OUTLINE

Reference: H02-0715-24 **Date of Decision:** 29th October 2024
Applicant: Mr I Collins
60 Peterborough Road
Crowland
Peterborough
PE6 0BA
Location: Rear Of 60 Peterborough Road Crowland Peterborough
Description: Erection of detached dwelling

South Holland District Council hereby give notice that this application has been REFUSED for the above proposal for the following reason(s):

Client:	MR. I. COLLINS	Proposal:	PROPOSED NEW DWELLING R/O 60 PETERBOROUGH ROAD, CROWLAND	Scale @ A3 1 : 250	Title PROPOSED BLOCK PLAN INDICATIVE DWELLING
	JANICE KENDRICK DESIGN SERVICES		e-mail- jkds@talk21.com tel : 07711 007209	Dwg No. 24. 3575. 06

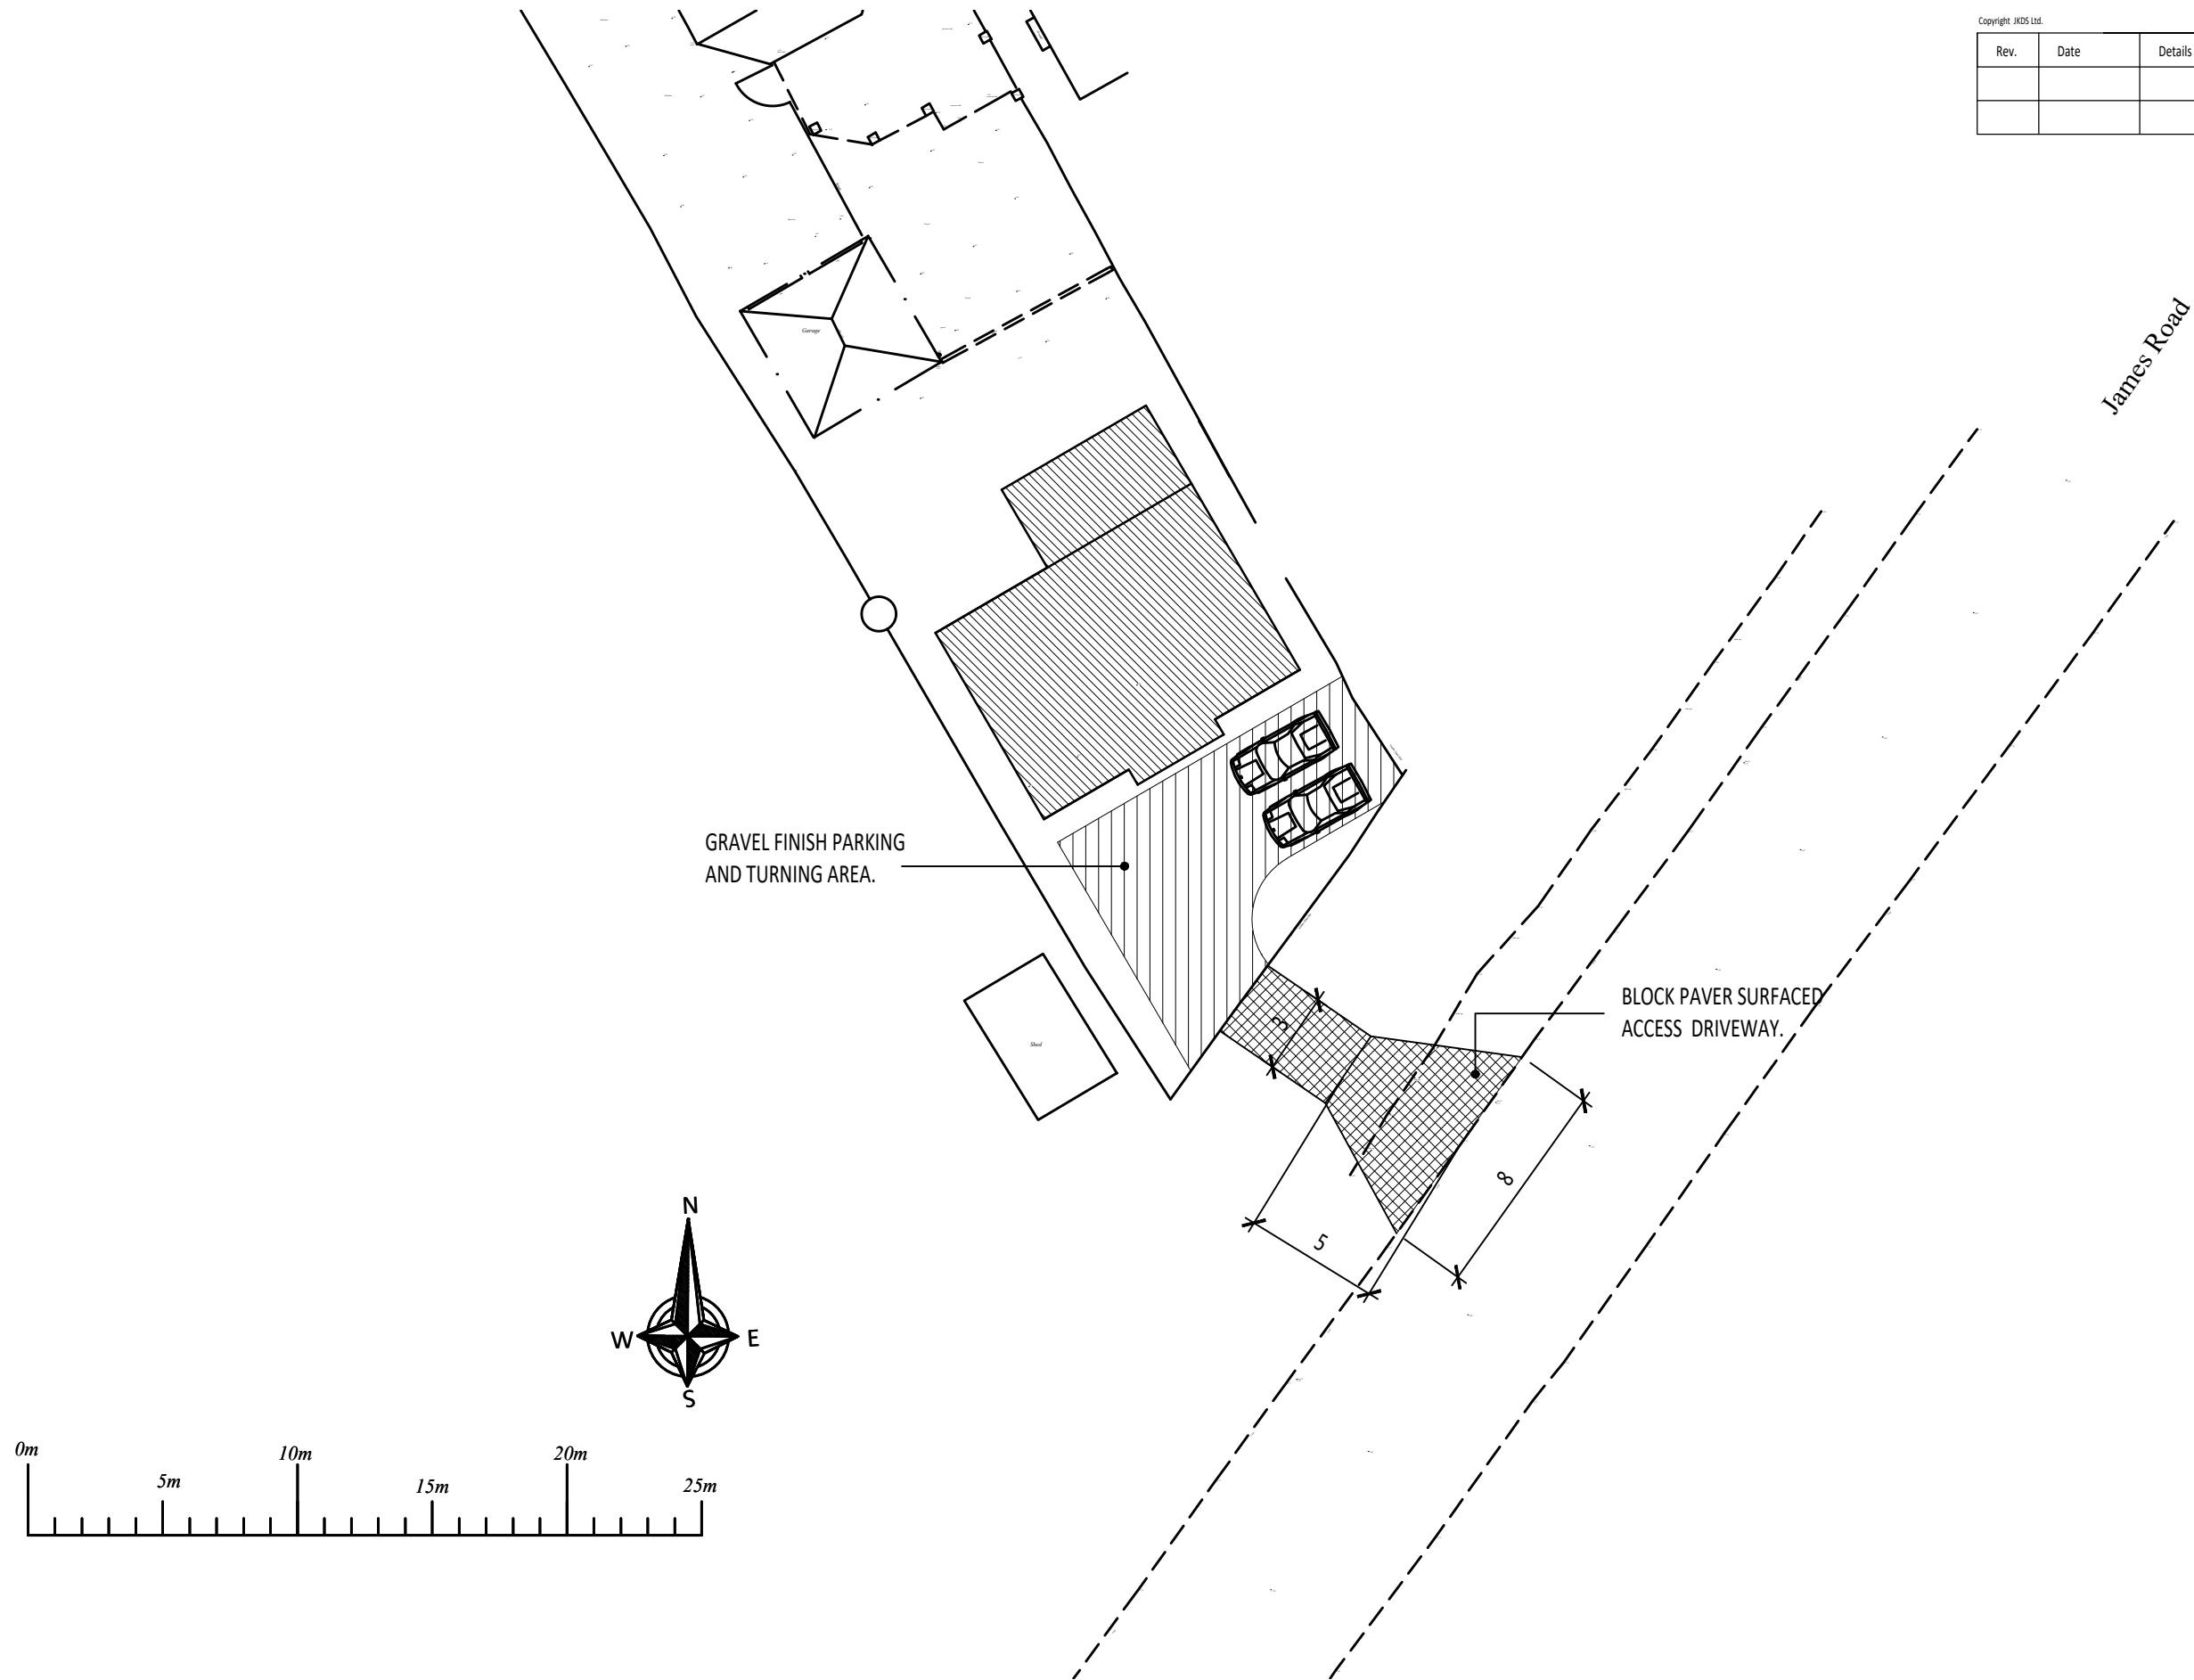
- 1 The proposal, by reason of its size, siting, bulk, massing, and subdivision of the original plot, represents inappropriate, incongruous and a cramped form of overdevelopment which is out of keeping with the prevailing form of development in the locality, causing an adverse impact, eroding the character and appearance of the area.

The proposal constitutes development that is symptomatic of overdevelopment of the site, resulting in an inappropriate form and a cramped environment. The proposal introduces 'backland' development; thereby adversely affecting the character. Furthermore, the proposal introduces a new access onto James Road with no pedestrian access to Peterborough Road, further impacting upon the character and appearance of the area.

The proposal fails to respect the traditional pattern of the surrounding area, comprising of long narrow plots with dwellings set back and fronting Peterborough Road, with pedestrian access to that road, and introduces a new vehicular access off James Road which is out of character of the area.

- 2 The proposal would result in a reduction to a significant proportion of amenity space and potential landscaping of the original site, No. 60 Peterborough Road. In addition, the resultant development would provide limiting available amenity space and potential landscaping to the proposed dwelling and plot. Cumulatively, the proposal decreases the overall plot size and therefore adversely impacts upon the amenity space of No. 60 Peterborough Road and would provide an unsuitable resultant amenity space to both the proposed dwelling and that serving No. 60 Peterborough Road.

- 3 The proposal, by reason of its size, siting and proximity to neighbouring properties, would adversely affect the residential amenities of existing nearby residential development at 58 and 60 Peterborough Road, together with future occupiers of the proposed dwelling, resulting in loss of outlook, privacy and overlooking.
